SUBJECT: Polk County, Replace Bridge Number 193 on SR 1508 over UT
to the North Pacolet River; State Work Order Number
8.2980901; TIP Number B-4240

Polk County
Bridge No. 193 on SR 1508
Over UT to the North Pacolet River
Federal Aid Project BRZ-1508(3)
State Project 8.2980901
TIP No. B-4240

GENERAL PERMIT (REGIONAL AND NATIONWIDE) VERIFICATION

SUBJECT: Review of NCDOT's request for Section 404 and 401 Permits to replace Bridge No. 193 on SR 1508 (Scriven Road) over an unnamed tributary to North Pacolet River, Polk County, North Carolina. TIP No. B-4240.

PROFILE ALONG CULVERT

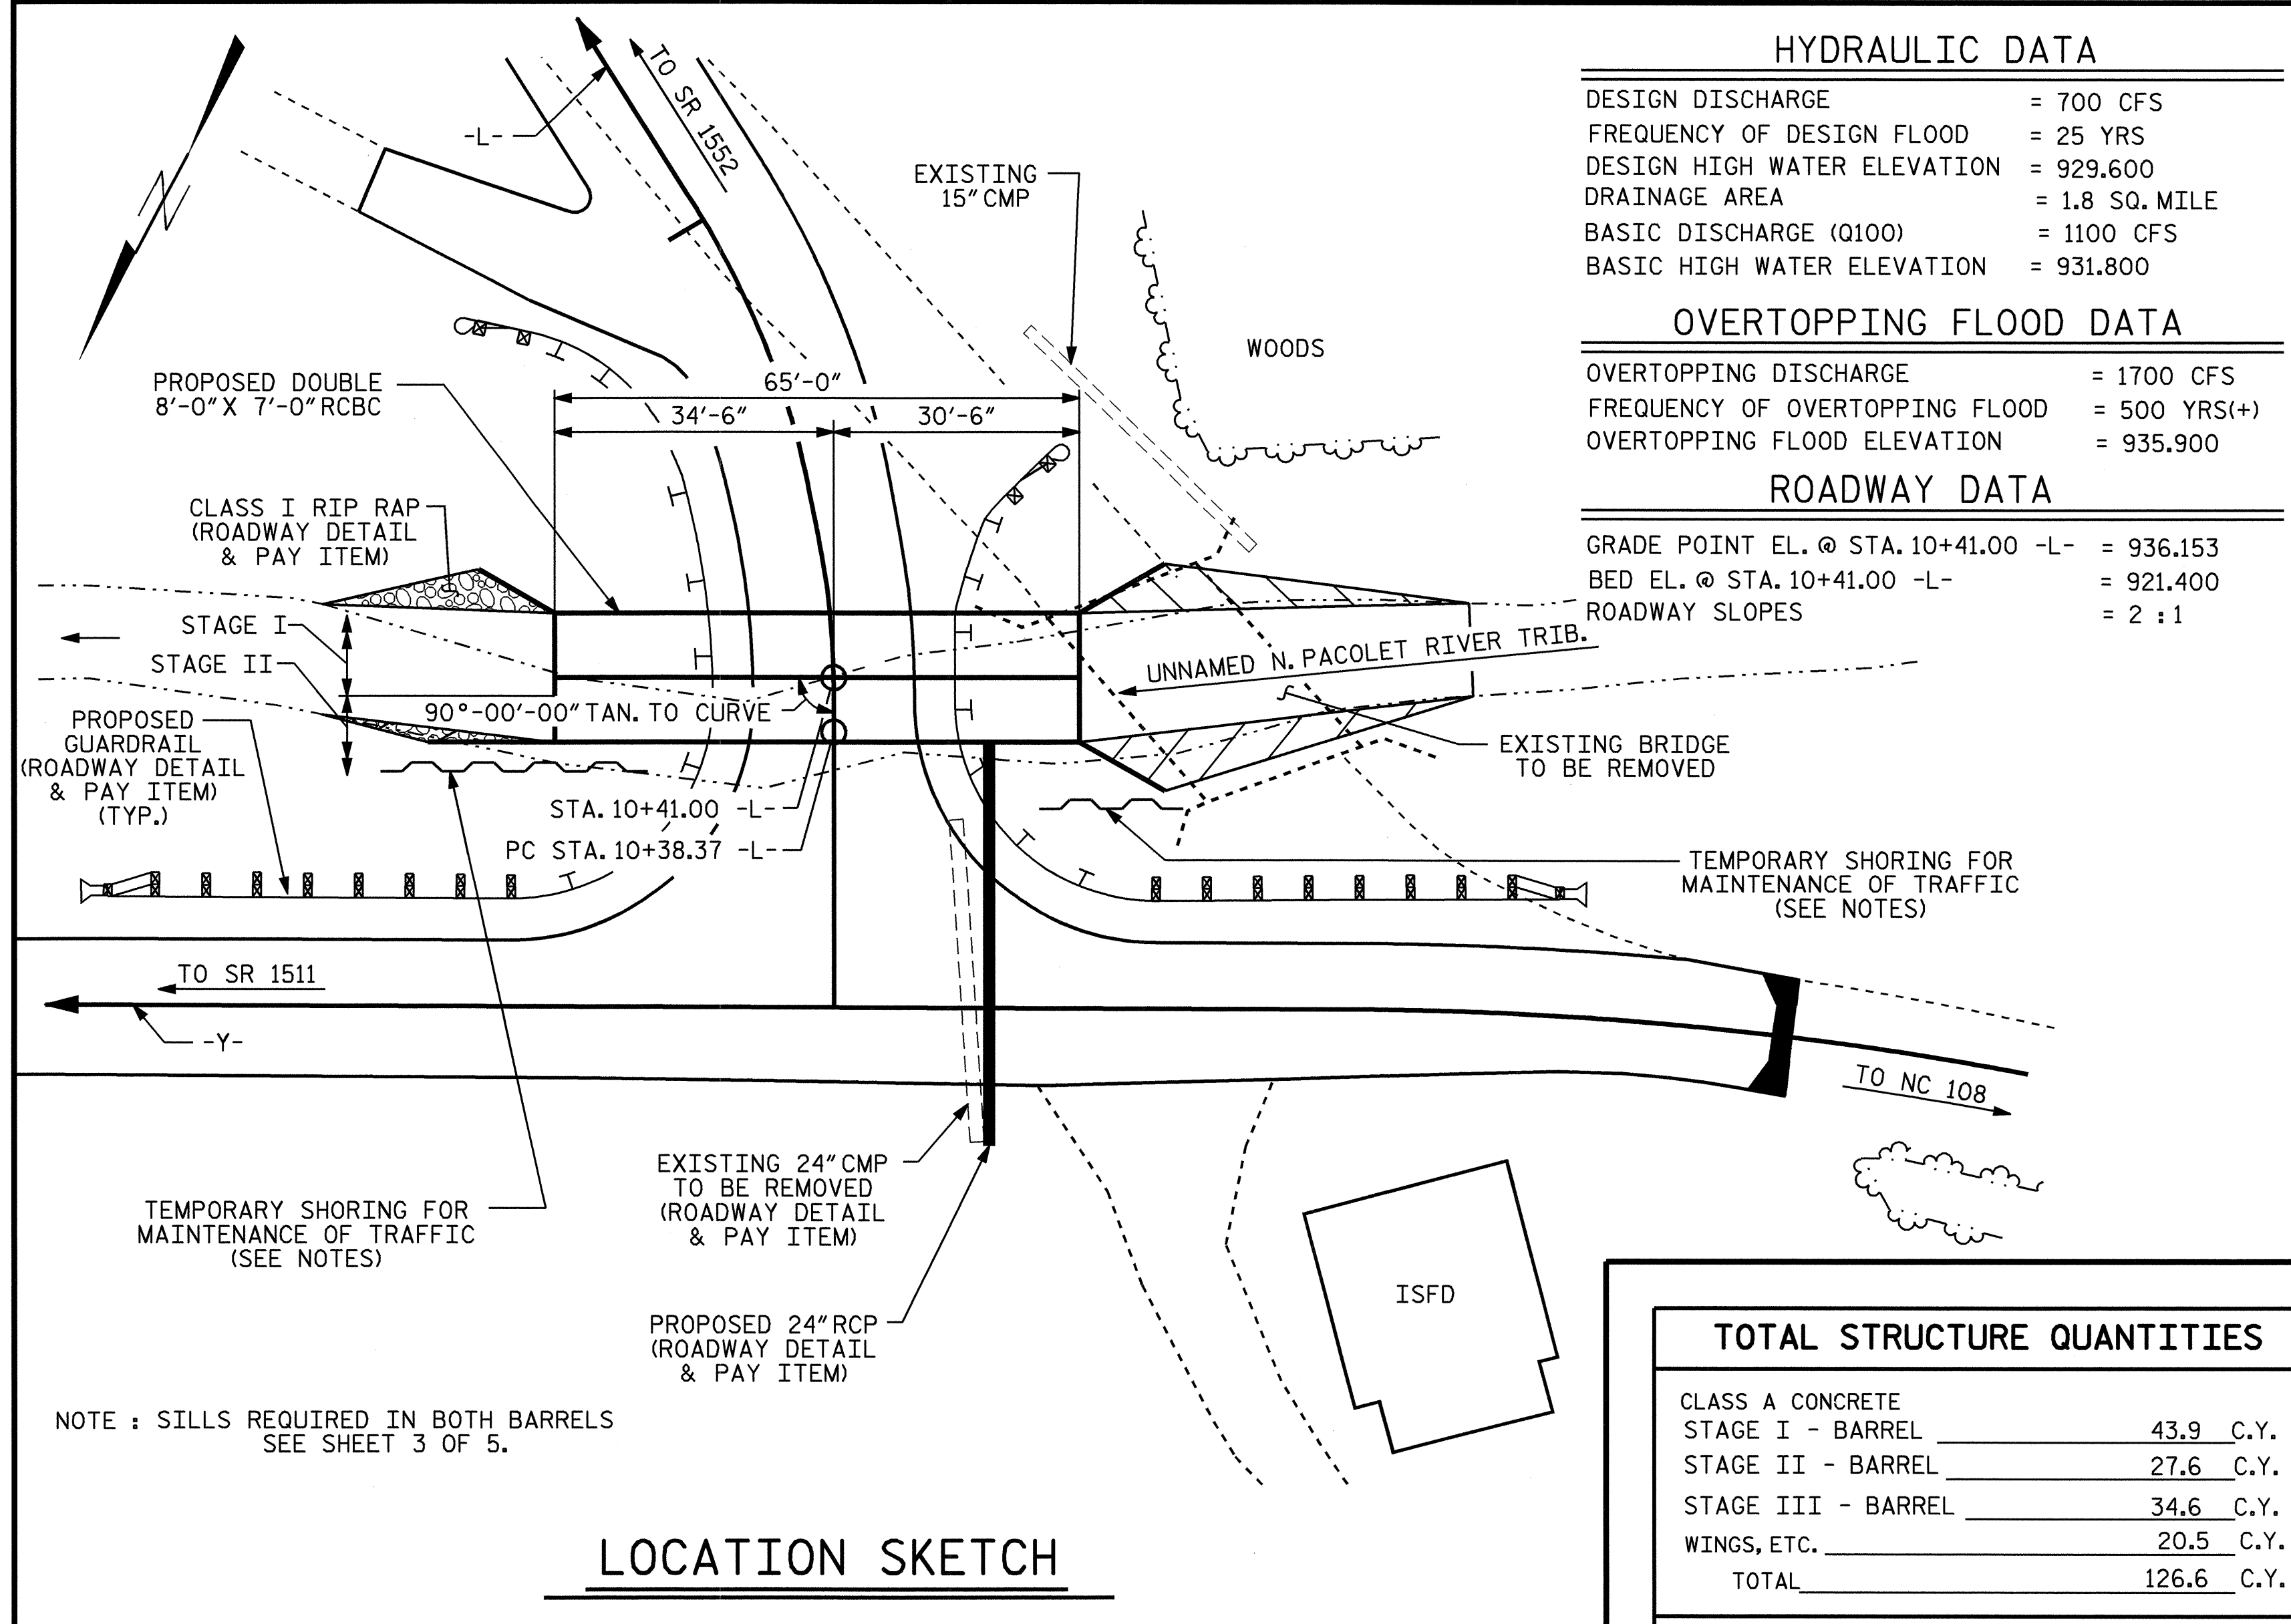
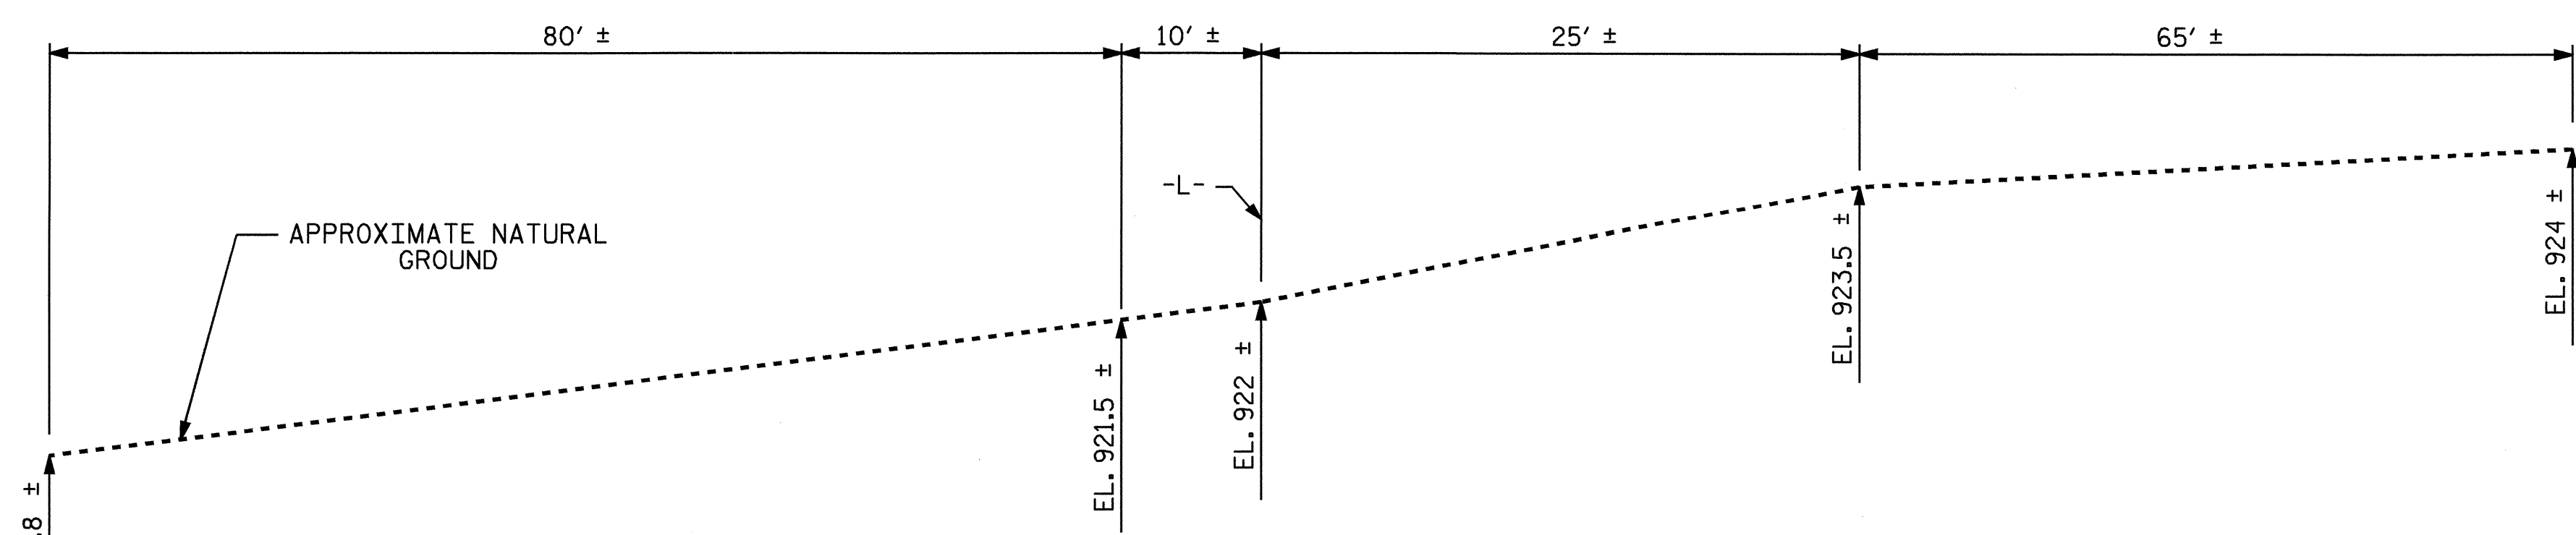
4. If a culvert is used, it should be designed so that one barrel, of adequate size, will carry the base flow, and the others will carry stormwater. Barrels other than the base flow barrel should be placed on or near bankfull or floodplain bench elevation (similar to Lyonsfield design). This may be accomplished by utilizing sills on the upstream end to restrict or divert flow to the base flow barrel. Culverts that are 48-inch diameter or larger should be placed with the floor of the barrel approximately 12 inches below the stream bottom to allow natural stream bottom materials to become established in the culvert following installation and to provide aquatic life passage during periods of low flow. This may require increasing the size of the culvert to meet flow conveyance requirements. These measurements must be based on natural thalweg depths.
